STAGE 1 ROAD SAFETY AUDIT **OVERSEEING ORGANISATION RESPONSE** **REPORT**

SECTION 38 WORKS

ROWLEY LANE, FENAY BRIDGE

Ref: E23/8060/JM/004A

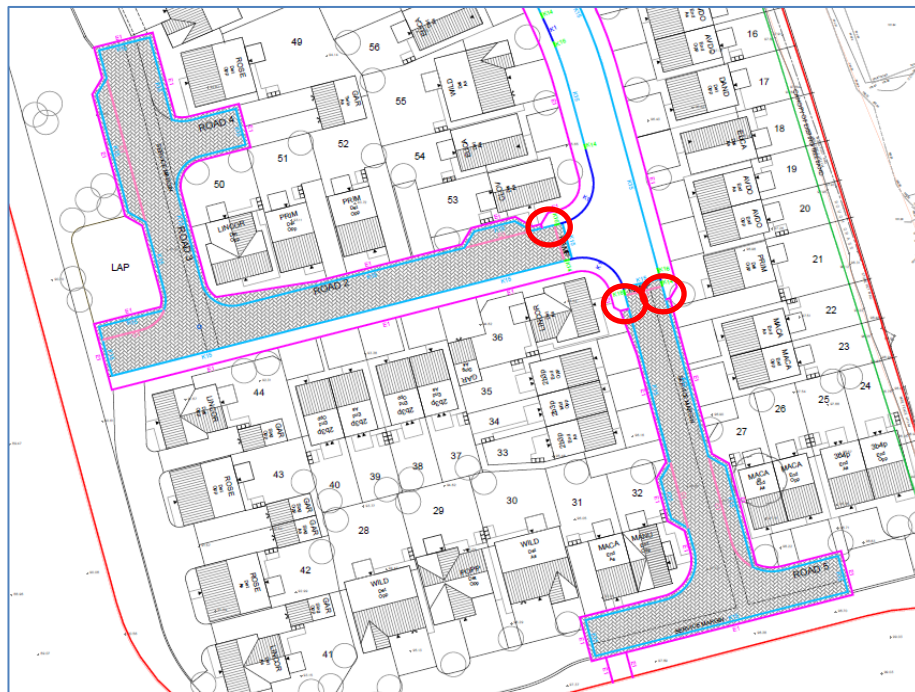
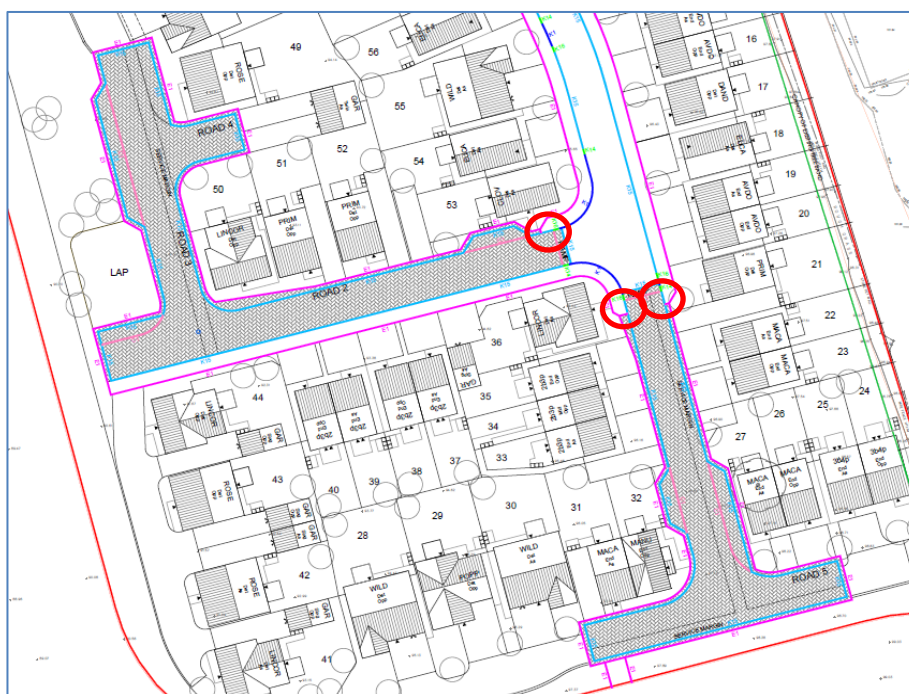
Problem 2.2.**Location:** Footways on Road 1 and Road 2 at transition from conventional street with footways on both sides to shared surface treatment**Summary:** Risk of pedestrian trip/fall injuries due to lack of suitable connection between footway and carriageway

Stage 1 – Observations & Recommendation	Observations – At the transition from conventional street with footways on both sides to shared surface treatment, it is assumed that the intention is for pedestrians to continue their journeys on carriageway. However, there appears to be a 30mm bull nosed kerb proposed at the footway/shared surface interface. A kerb with even a reasonably small upstand could increase the risk of pedestrian/trip fall injuries and may physically prevent those in wheelchairs/mobility scooters from accessing the shared surface area. Recommendation – It is recommended that a suitable flush transition between conventional footway and shared surface areas is provided.
Designers Response	In accordance with RSA recommendation, drawings to be updated to incorporate a flush kerb at the top of ramps to allow pedestrians to transition onto the carriageway.
Overseeing Organisation	Agreed.

Response	
Agreed RSA Action	Drawings to be updated to incorporate changes.
